Please find attached the amended drawings indicating the revised roofline, floor plans and elevations as requested.

I have been to site and I am largely happy with the proposed scheme. I do have a concern regarding the impact of the new northern flank half hipped roof on the amenities of the flank bedroom window to the top floor flat in no. 7. I appreciate that you were previously advised in design terms to avoid a hipped roof on this elevation but I would ask if this could be reinstated as it will make the situation better for the outlook from the neighbouring window (i.e. put the north elevation roof back to how it was at pre-application stage). If you do this then I can recommend the application for approval.

DRAWING TITLE
PROPOSED SITE PLAN
AND BLOCK PLAN

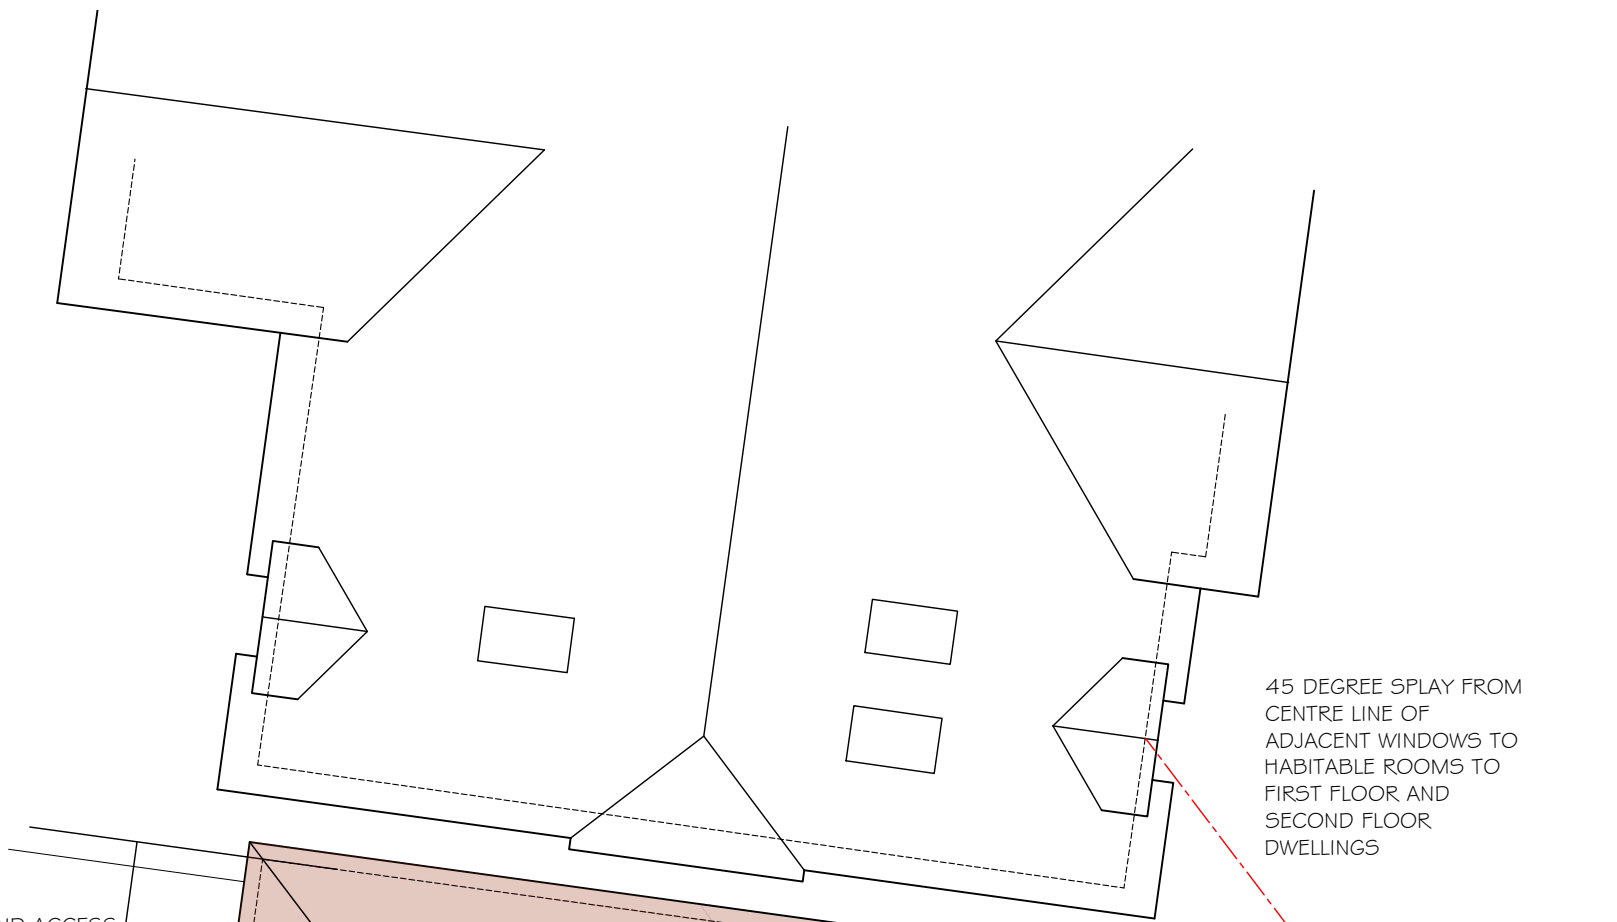
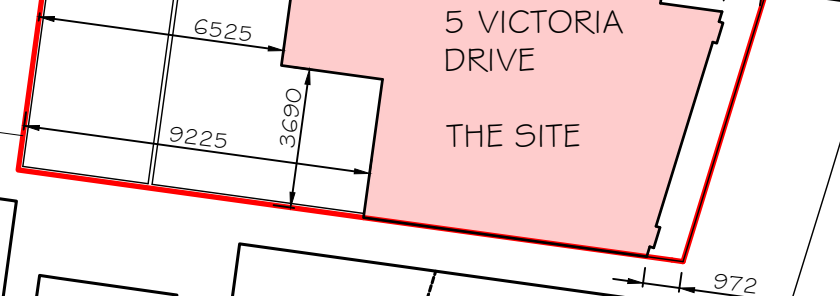
Separately, I note that the application red edge includes the access through the site into the car park and that you have not served notice on any other landowners. Can I just check that your client does own this section of the access? If not, then you will serve notice on the owners.

Our client has confirmed that he is the sole owner of all of the land identified to be within the red line and grants access across his land for the users of the car park area at the rear.
